45-53 Macleay Street Potts Point

Response to Submissions

This Submissions Report has been prepared by Urbis on behalf of Time & Place Pty Ltd (**the Applicant**) to address the matters raised during the public exhibition of the State Significant Development Application (**SSDA**) for the redevelopment of 45-53 Macleay Street, Potts Point (SSD-79316759).

1 ENVELOPE PLAN - GROUND FLOOR & BELOW
 1 : 200

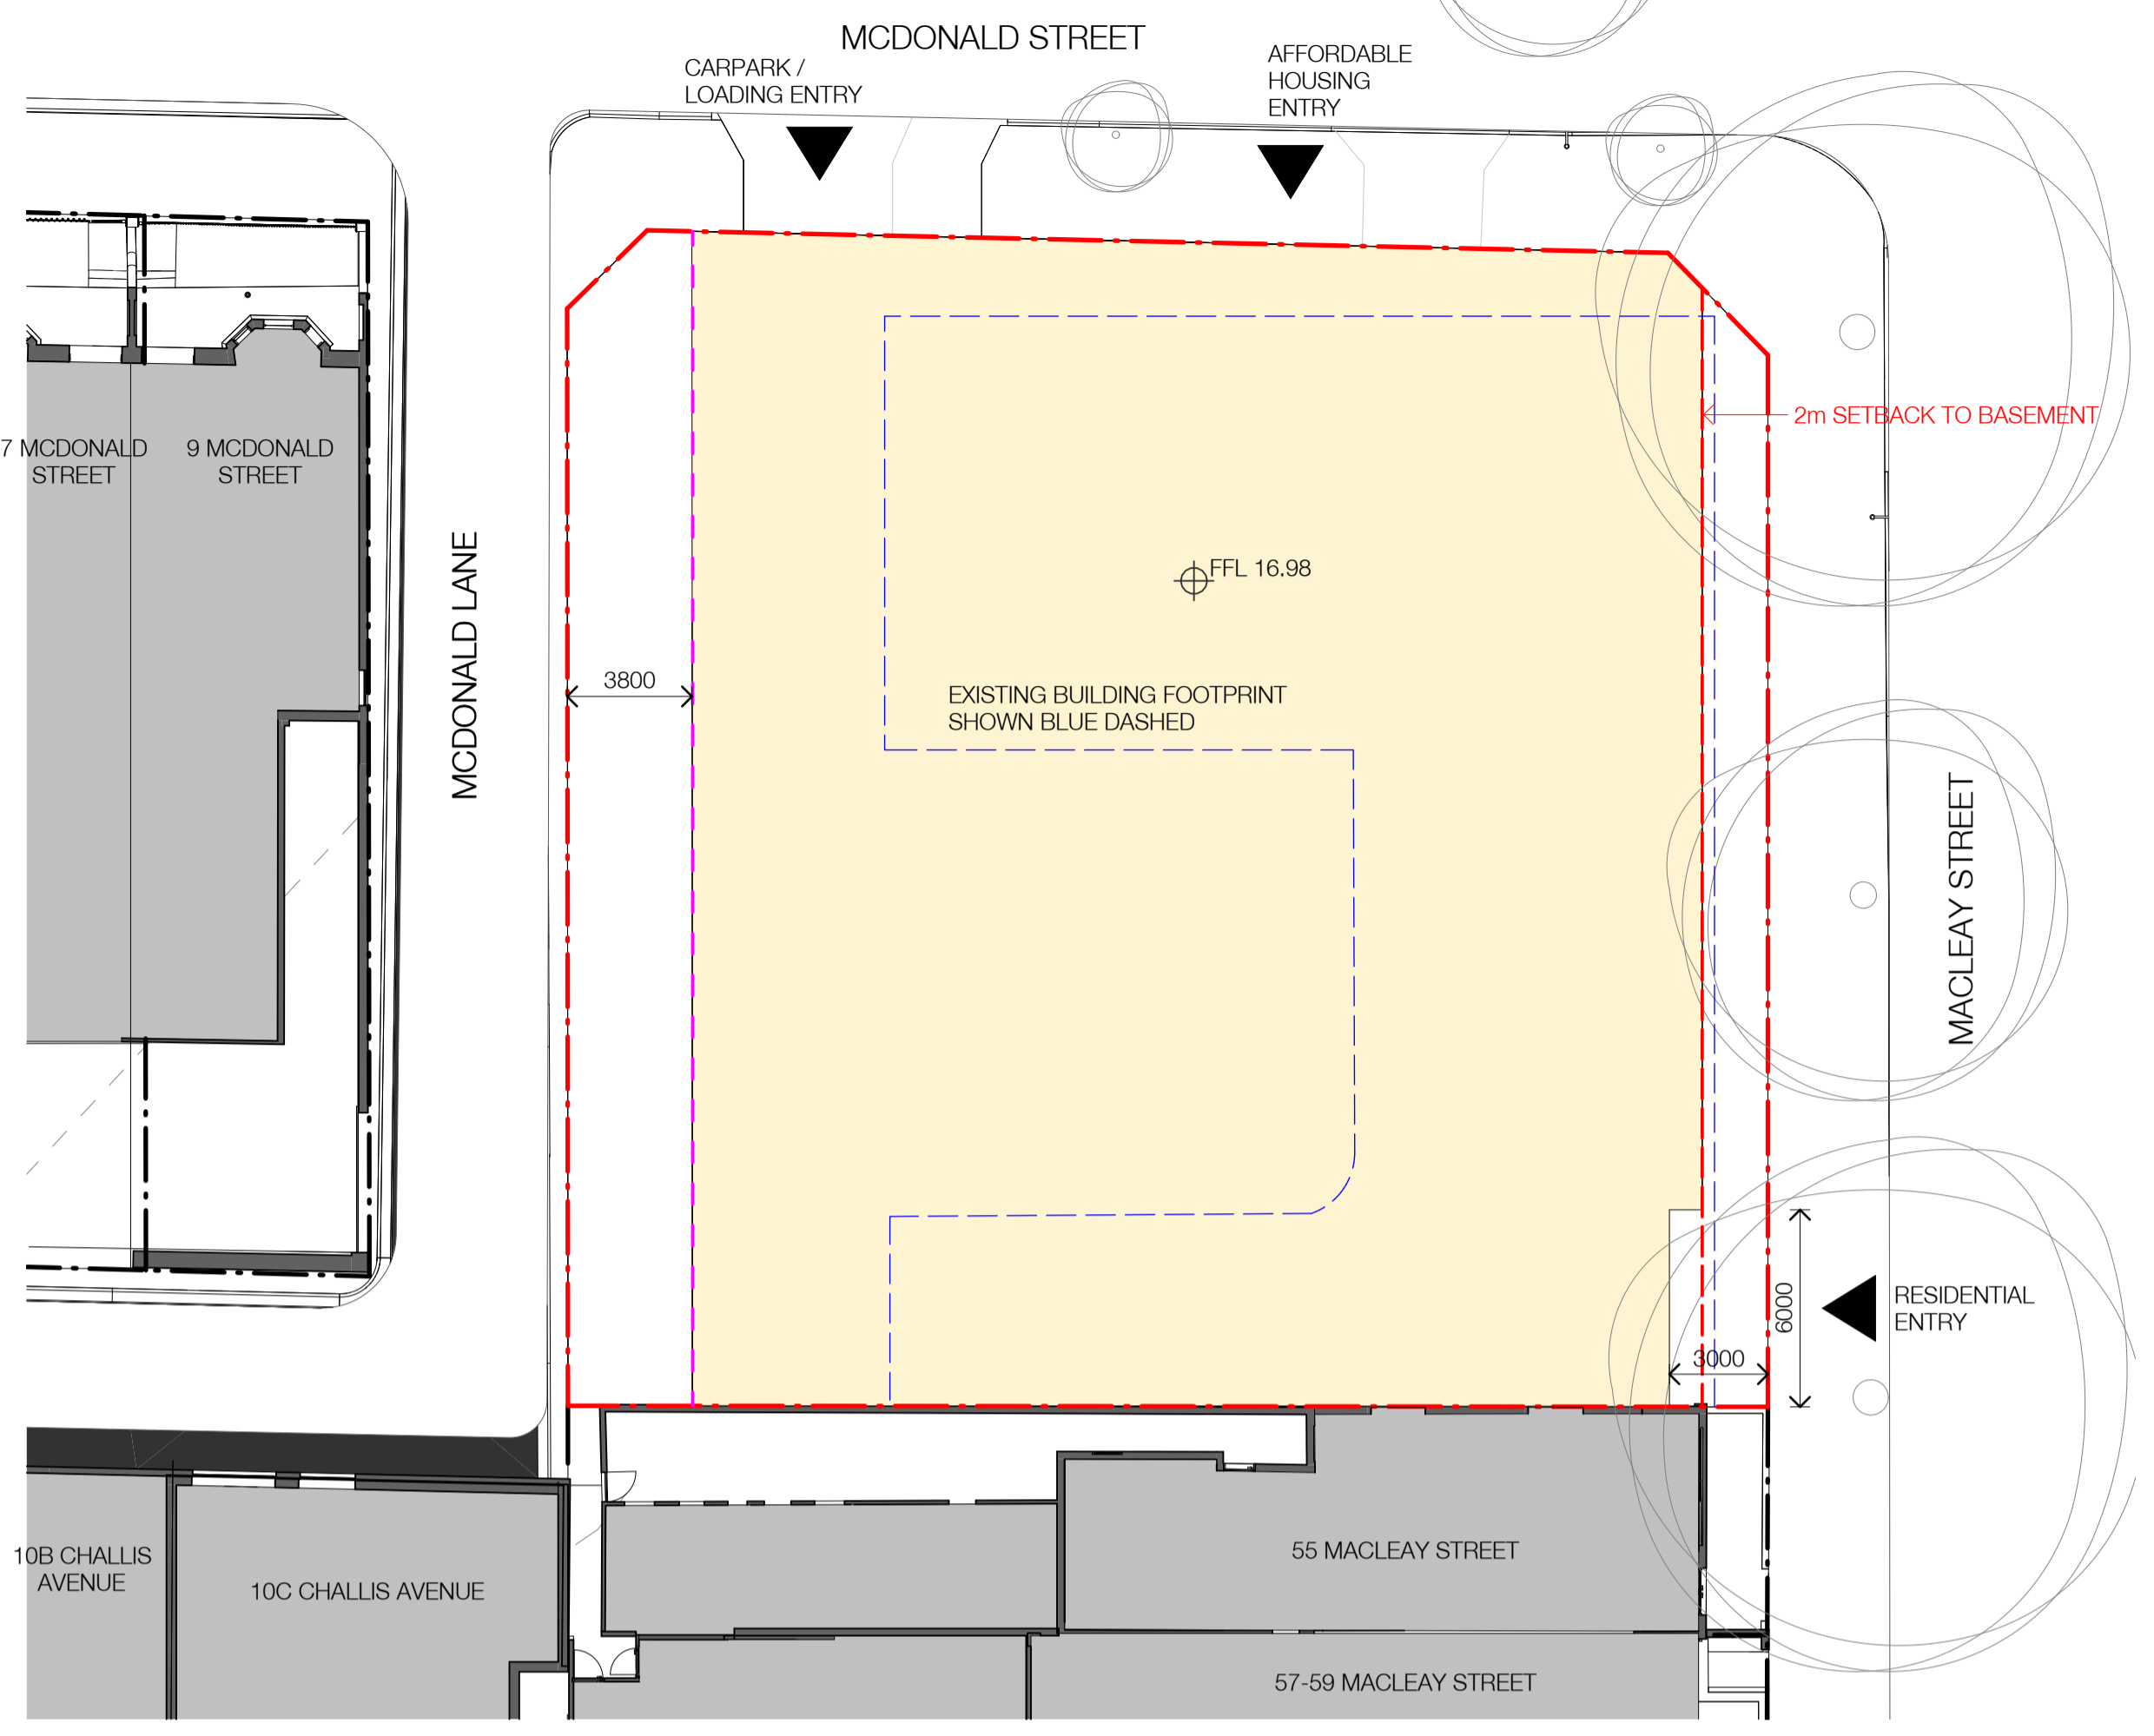
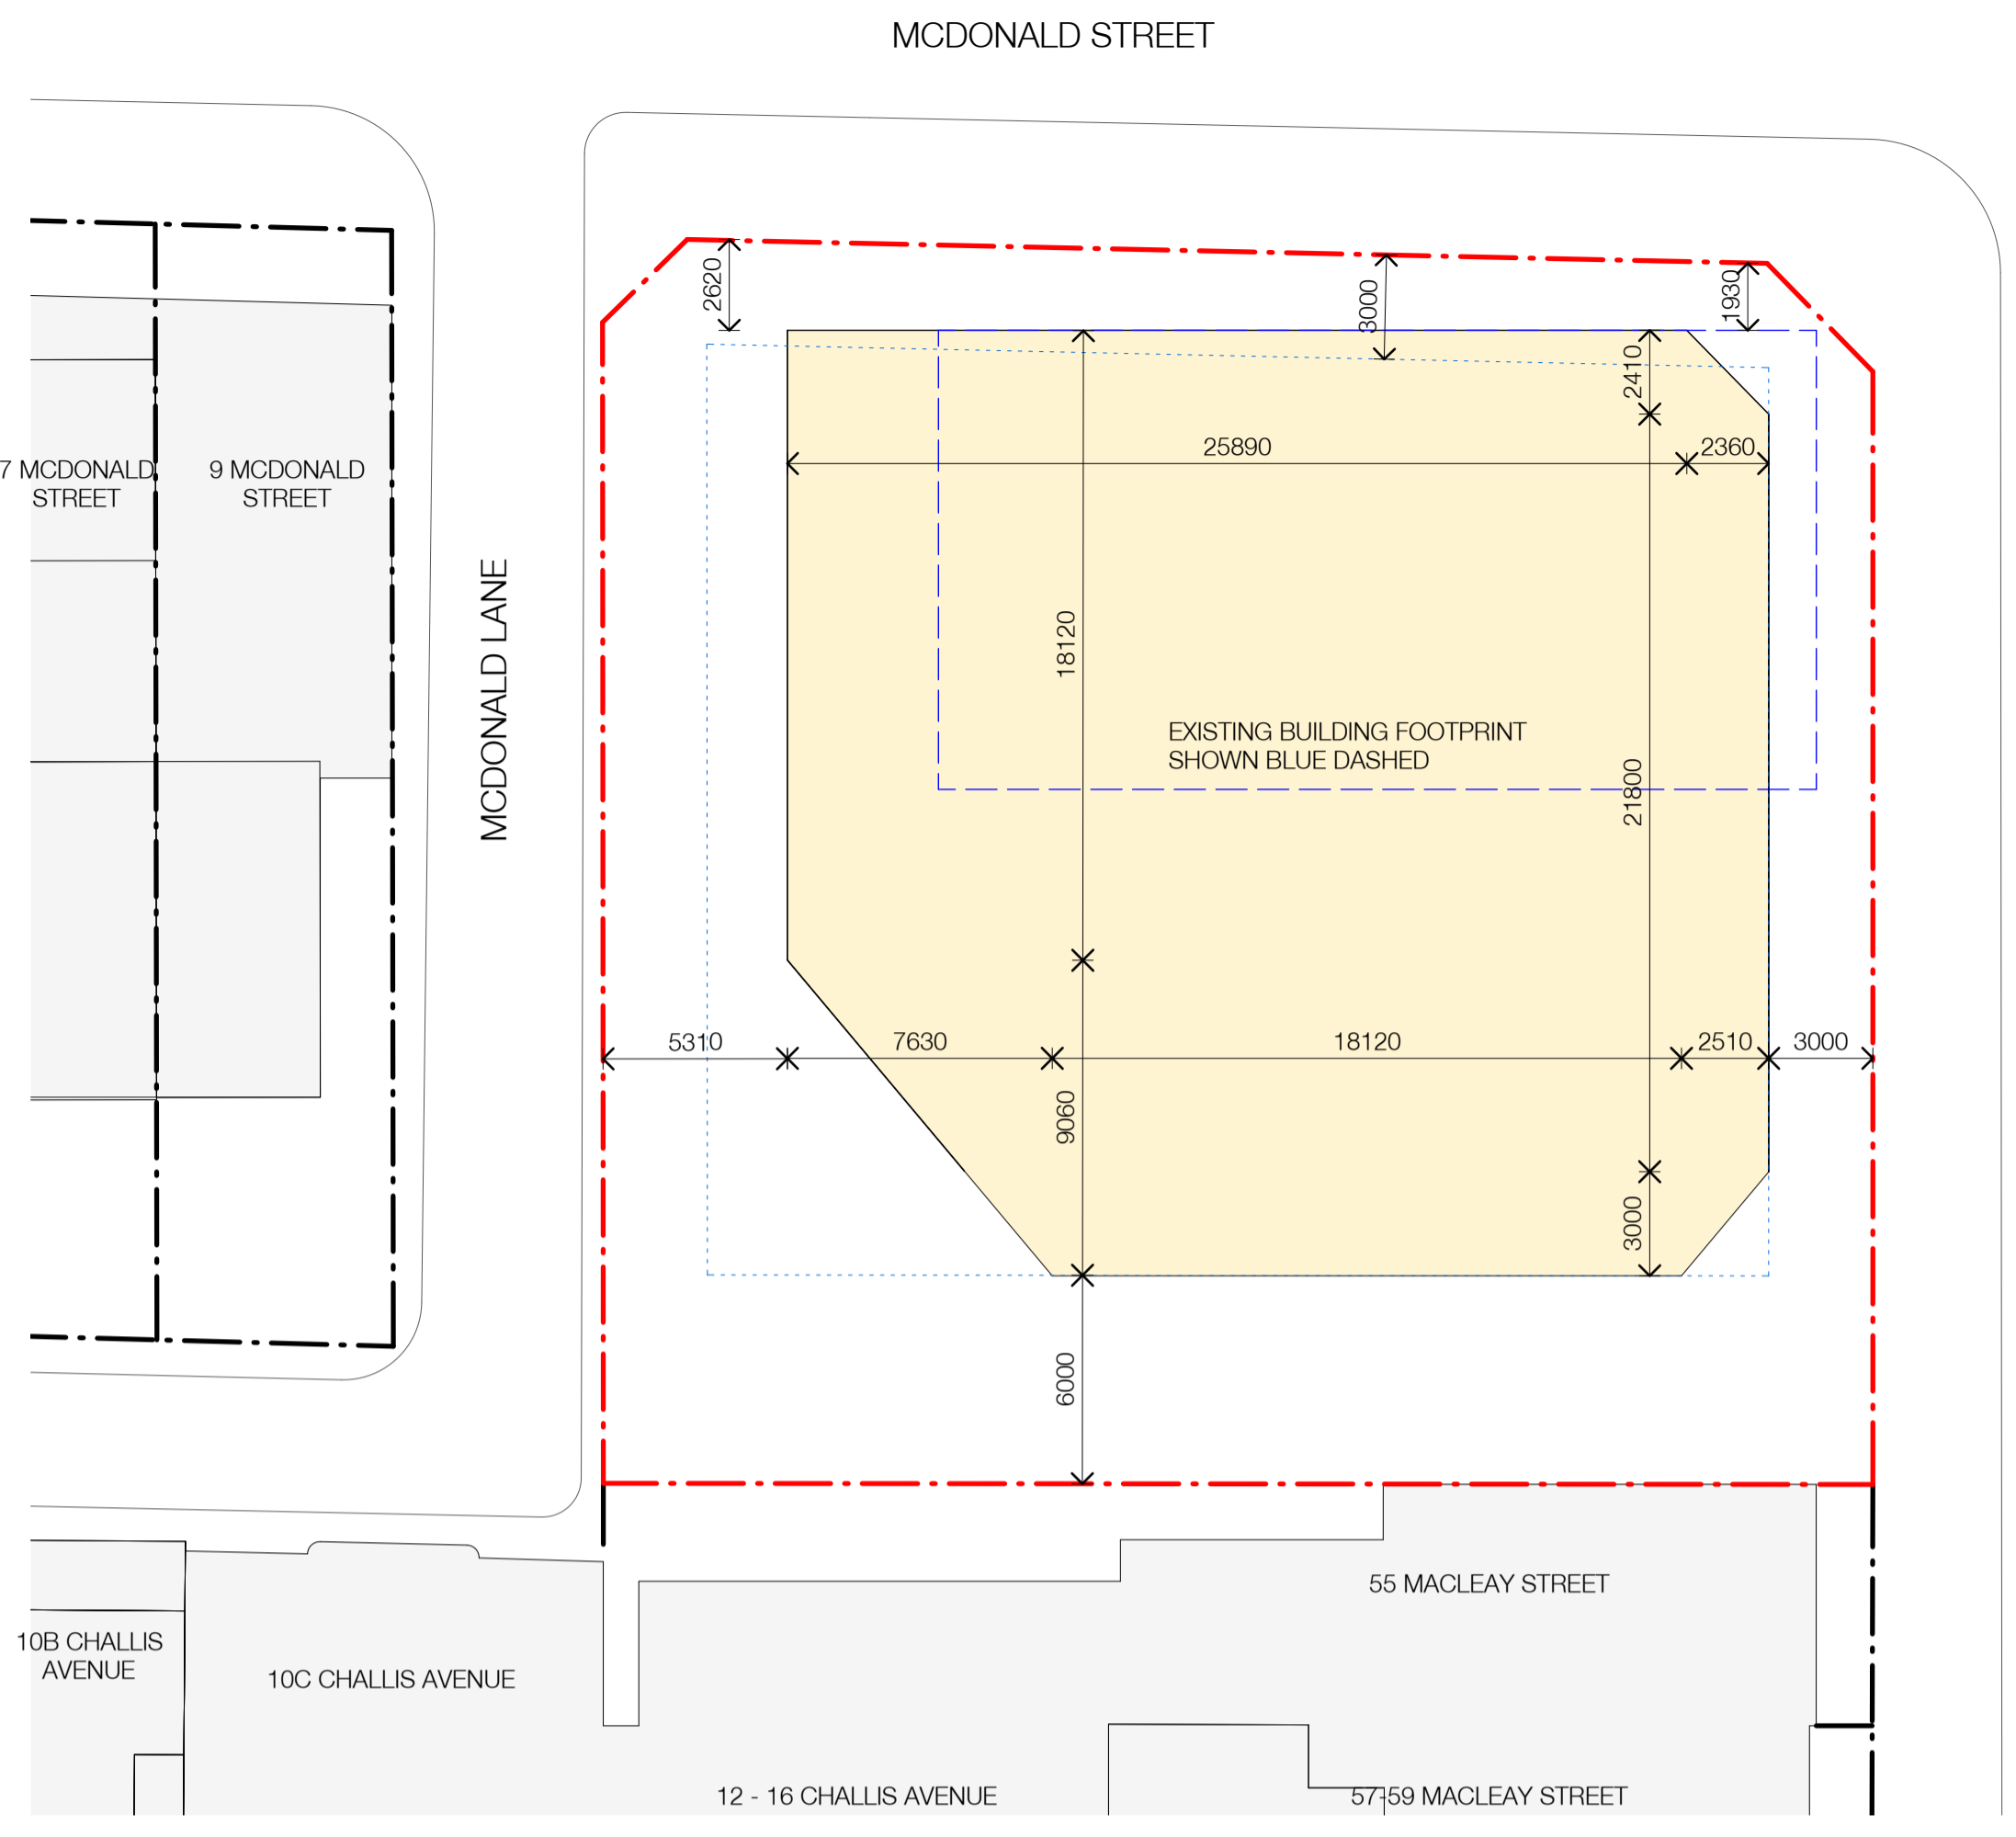
Building setbacks / building envelope		
<ul style="list-style-type: none"> ▪ The proposed building envelope setbacks are unclear and inconsistent. The setbacks dimensioned on the building envelope plans, and as noted in the EIS, do not appear to be measured from the proposed building envelope (depicted in yellow). Detail the setbacks from the proposed building envelope and clarify what the blue dotted line is depicting on the building envelope plans and update the legend accordingly. 	<p>Updated envelope plans have been provided by SJB which include setbacks dimensioned from the proposed building envelope. The plans have been updated to clearly indicate that the blue dotted line depicts the existing building envelope.</p>	Appendix C
<ul style="list-style-type: none"> ▪ Provide an analysis demonstrating that the proposed building setbacks are consistent with the prevailing street pattern in the vicinity of the site. <ul style="list-style-type: none"> ▪ ▪ Address Council's concerns regarding the Macleay Street front setback and the impacts on existing street trees. 	<p>The Envelope Plans (Appendix C) have been revised to provide a 2m setback to Macleay Street from Ground to Level 2 which is largely consistent with the setback of the existing building on the site.</p> <p>From Level 3 to 12, the proposal includes a 3m setback to Macleay Street to maintain the three-storey street wall height which aligns with the prevailing street pattern in the vicinity of the site.</p> <p>The proposal includes a 3.8m setback to McDonald Lane from Ground to Level 2 and 5.3m setback from Levels 3 to 12.</p>	Appendix C Appendix E

<ul style="list-style-type: none"> ▪ The proposed basement setbacks are unclear and inconsistent. The building envelope plans include a notation stating there will be a 2m setback to the basement, whereas the elevation plans show the 'extent of basement' being to the property boundaries. Clarify the extent of basement excavation proposed. The extent of basement is also required to confirm the proportion of deep soil to be provided for the development. 	<p>Updated envelope diagrams have been provided by SJB which confirm that a 2m setback is provided to the basement.</p>	<p>Appendix C</p>
<p>Wind impacts</p>		
<ul style="list-style-type: none"> ▪ Public submissions and Council raised concerns regarding wind impacts. Provide an updated Pedestrian Wind Environment Assessment which details the wind impacts of the proposal on the surrounding locality. 	<p>A Wind Assessment has been prepared by CPP Wind Engineering Consultants (Appendix F) to assess the likely impact of the proposed development on the pedestrian wind environment, with wind activity from north-easterly, southerly and westerly winds assessed. The analysis of the wind effects relating to the reference scheme have been carried out in the context of the local wind climate, building morphology and land topography.</p>	<p>Appendix F</p>

Issue Raised	Response	RTS Reference
<ul style="list-style-type: none"> Deep Soil area should be clearly identified on the envelope drawings, including an annotation to identify the minimum quantum. 	<p>The Updated Envelope Drawings (Appendix C) demonstrate a 3.8m setback from the basement and ground floor levels to McDonald Lane to facilitate deep soil planting. The deep soil planting area is indicated in the Landscape Report provided at Appendix P to the EIS. The final details of the deep soil provision on the site would be confirmed as part of a future detailed application.</p>	<p>Appendix C</p>
<ul style="list-style-type: none"> Setbacks are not adequately dimensioned on the envelope drawings – the envelope should be readily replicable to inform the subsequent design stages. 	<p>Updated Envelope Drawings have been provided by SJB (Appendix C) which clearly dimension the proposed setbacks.</p>	<p>Appendix C</p>
